Design and Access Statement Plot B - Addendum

01997-WEA-OXFORD NORTH PLOT B-DAS-ADDENDUM-P02

This document is an addendum to the Plot B Design and Access Statement, 01997-WEA-OXFORD NORTH PLOT B-DAS-P01 submitted to Oxford City Council in March 2023 and Addendum P02 submitted in June 2023.

Following the initial Oxford North Plot B Reserved Matters Application submission further amendments have been reviewed following ongoing engagement with the specialist contractors. Issues were raised regarding buildability and embodied carbon which have led to a number of small amendments to the initial scheme.

Drawing Title
 Southern Wing East Gable End Bay Study

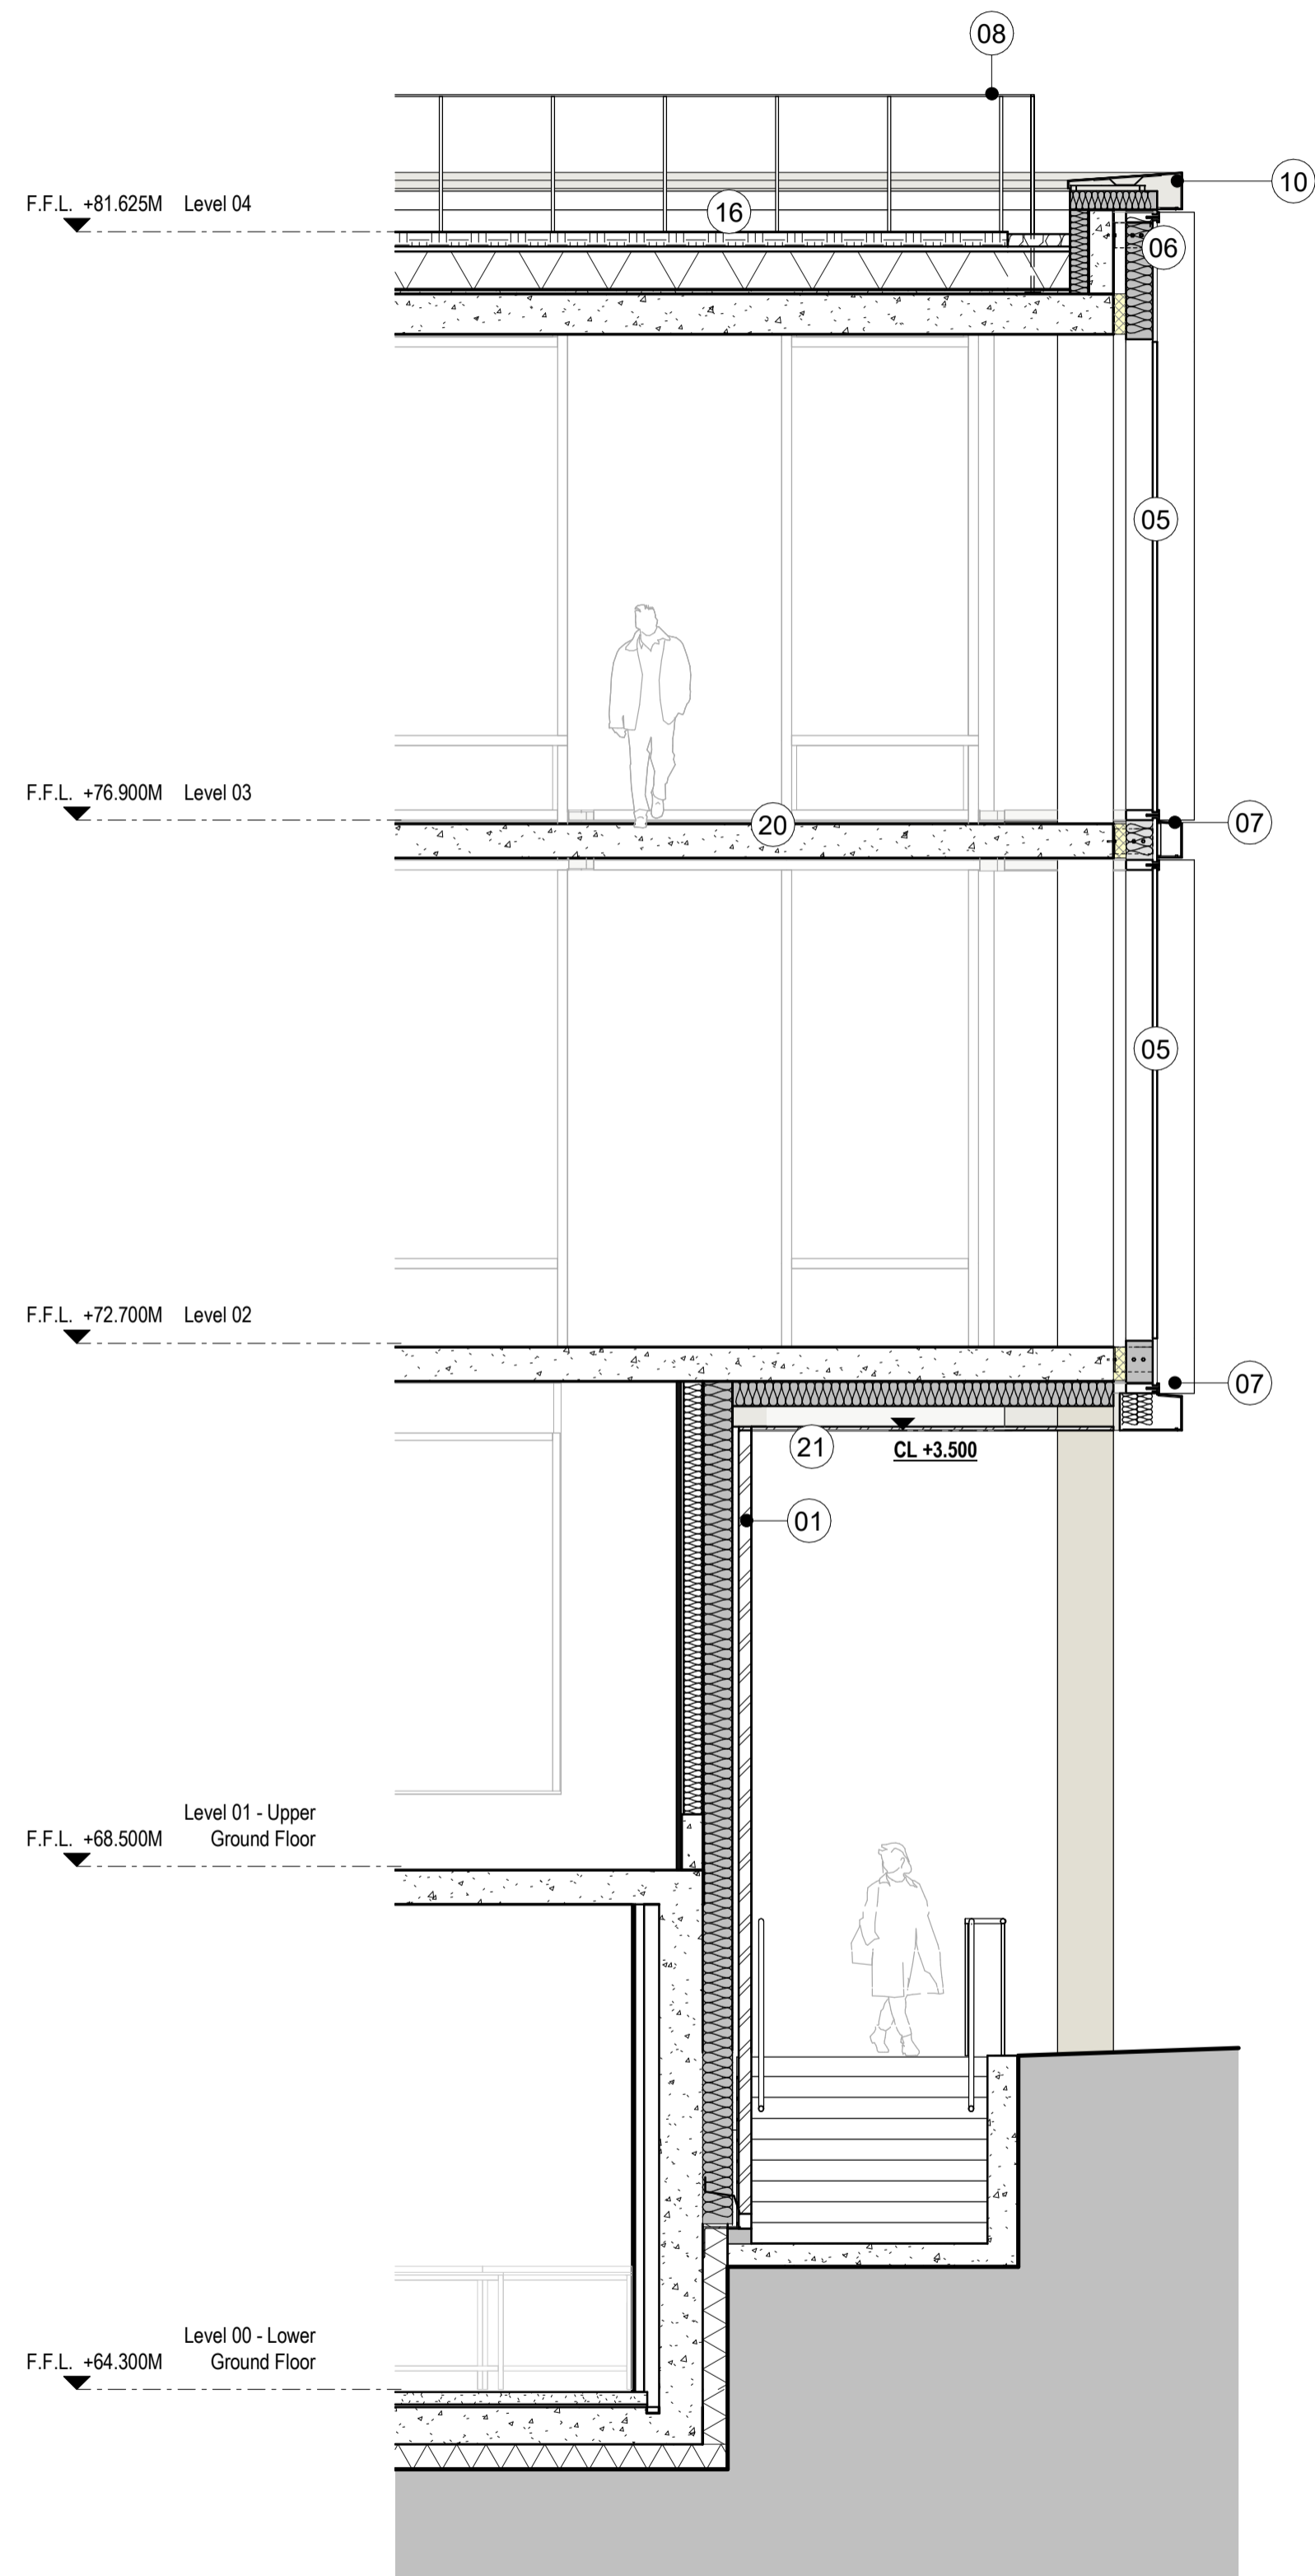
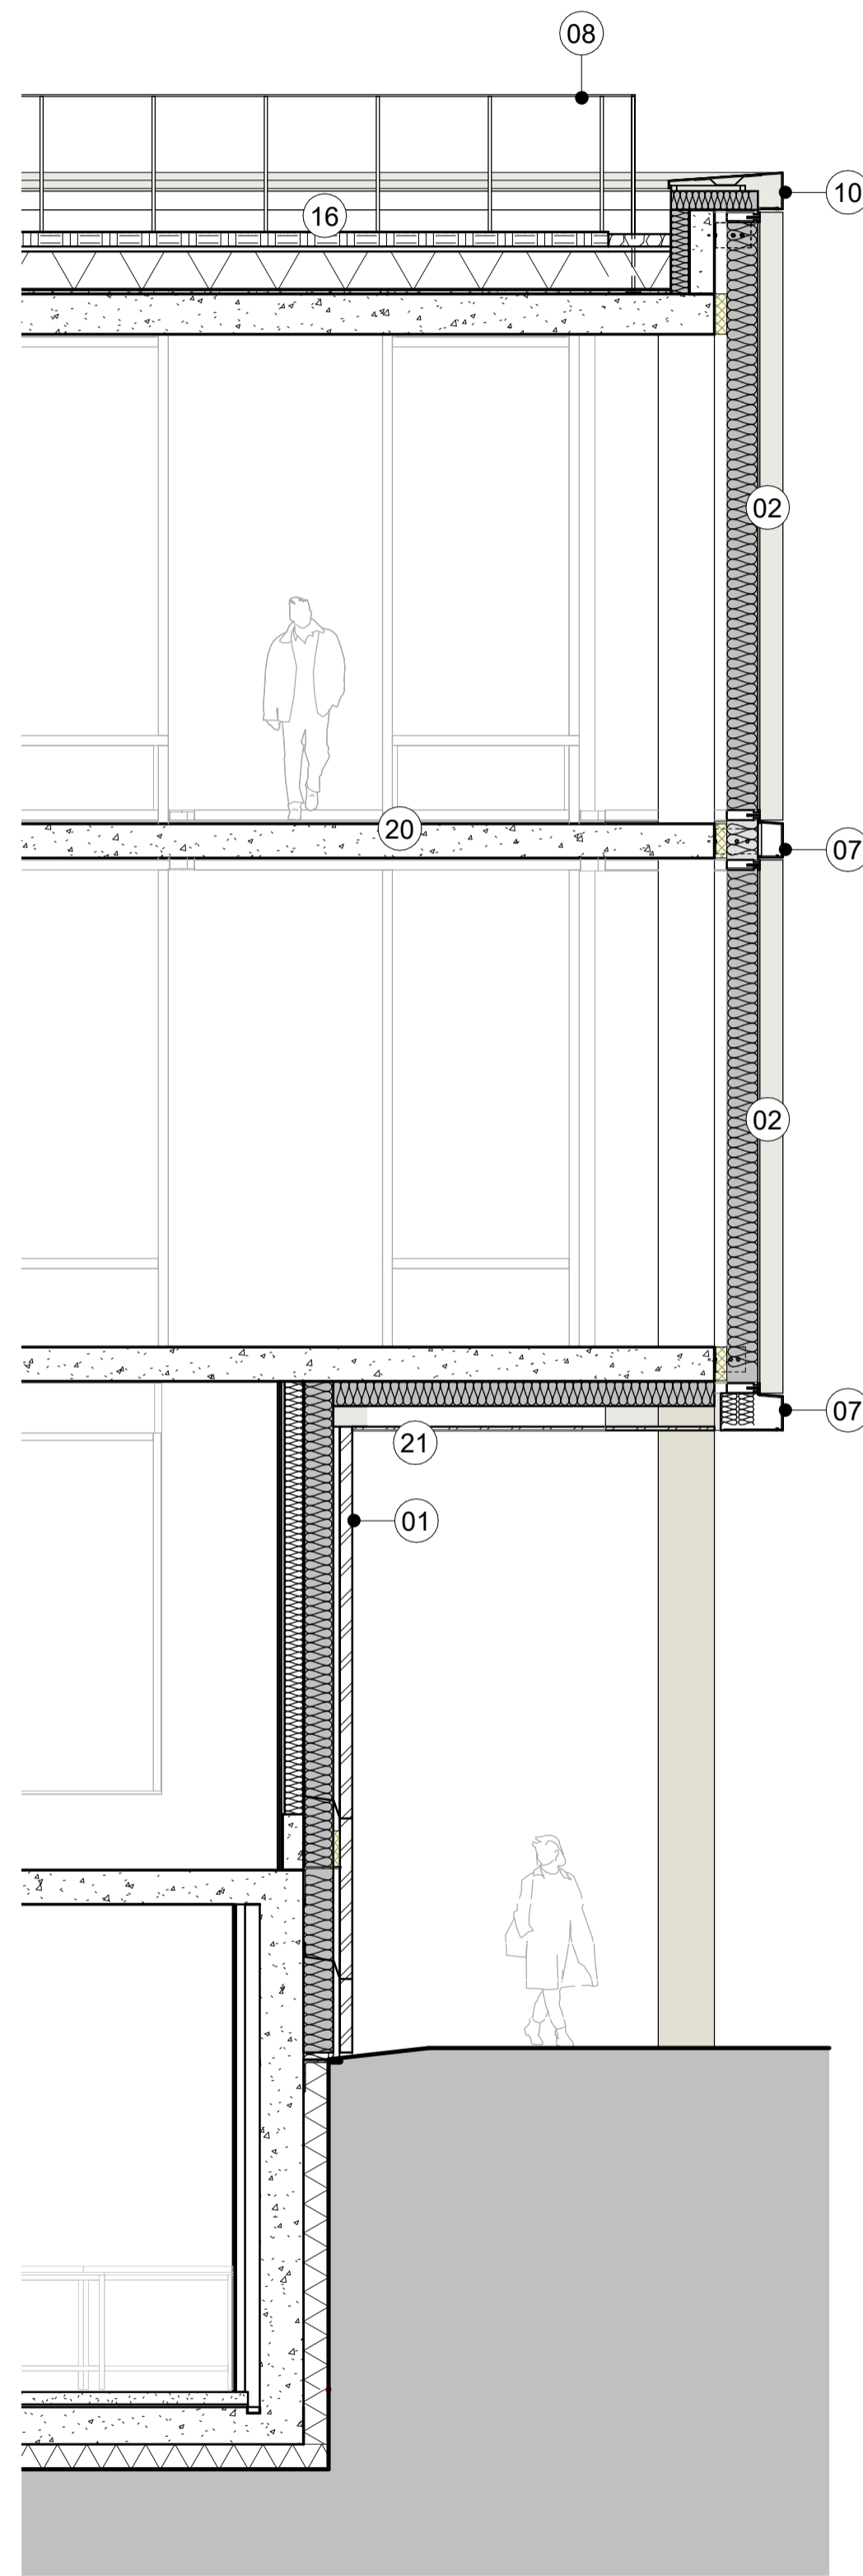
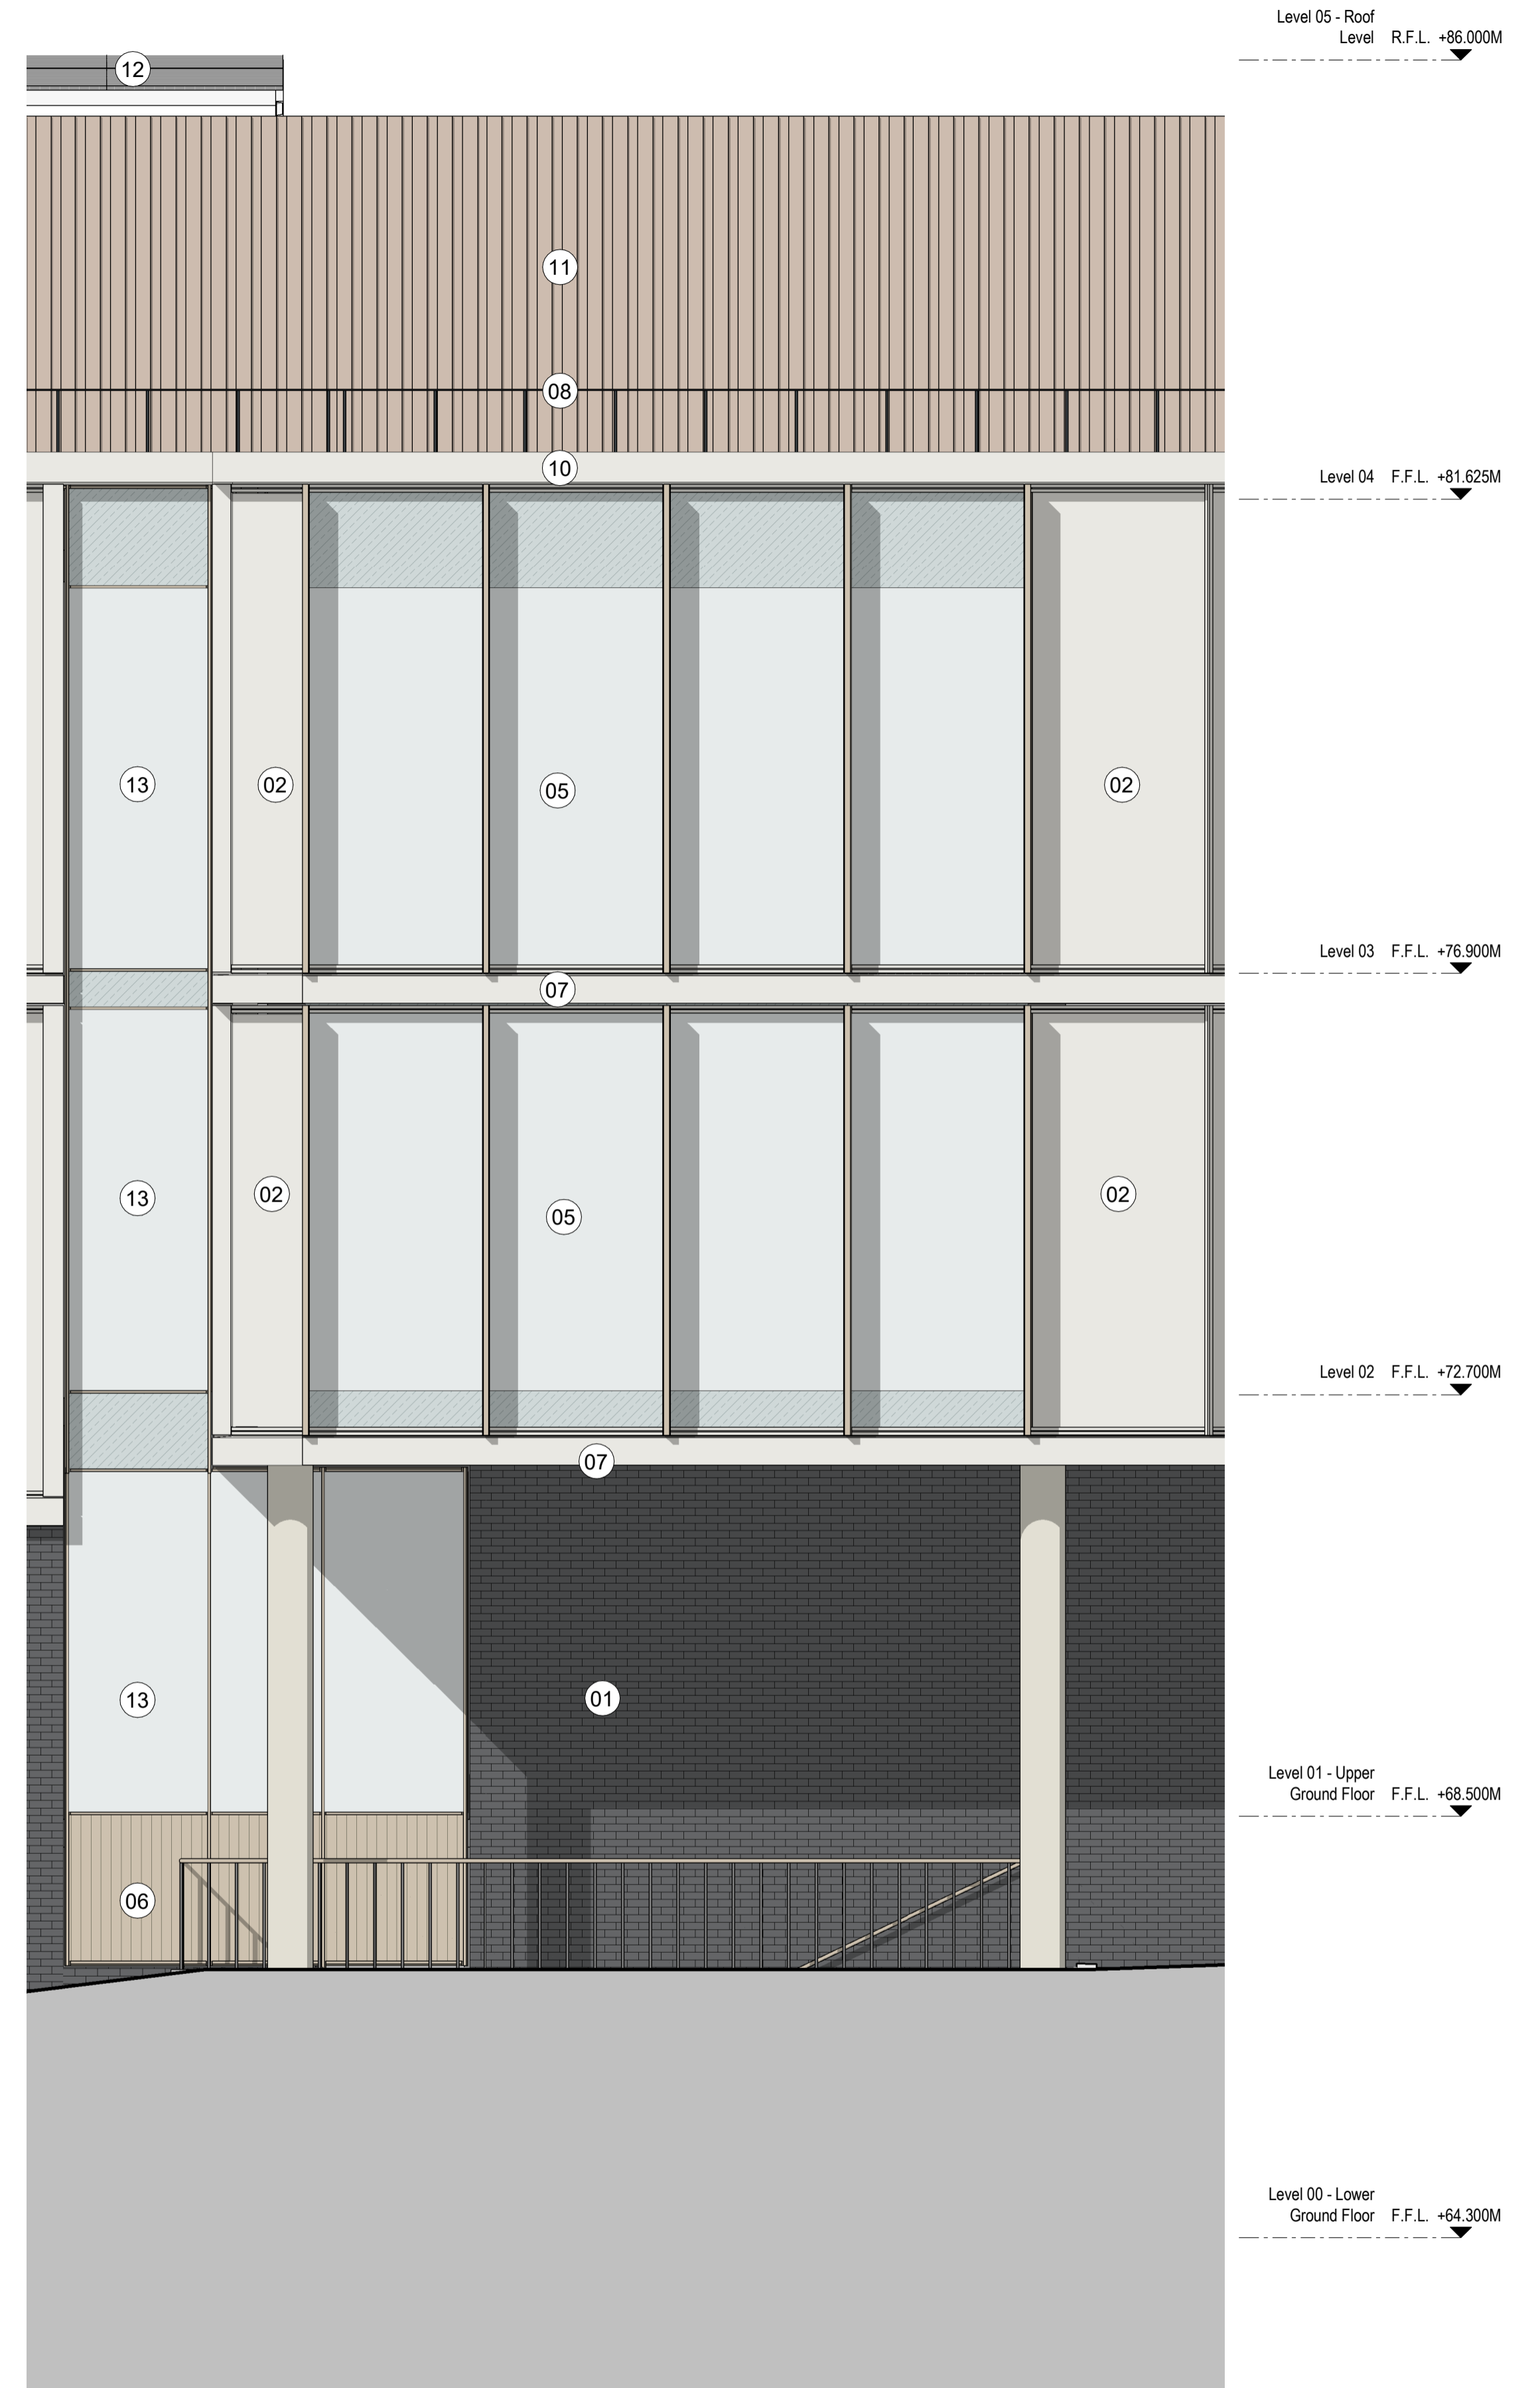
The re-working of the entrance facade also involved amending the flat areas of cladding and provide more articulation through the use of vertical fins. This was intended to enhance the elegance of the facade and was adopted as common approach to each of the wing gable end elevations.

The amendments to the articulation along the longer elevations has been minor and borne out of rationalising the amount of material used. The rhythm of the facade was developed as a vital design concept to work with the length. Reducing the depth of articulation aimed to strike a balance between providing suitable articulation to create a rhythm but limiting embodied carbon through excess material.

03- Facade articulation depth reduced

04- Flat cladding to gable end amended to vertical fins and setting out consistent along elevation
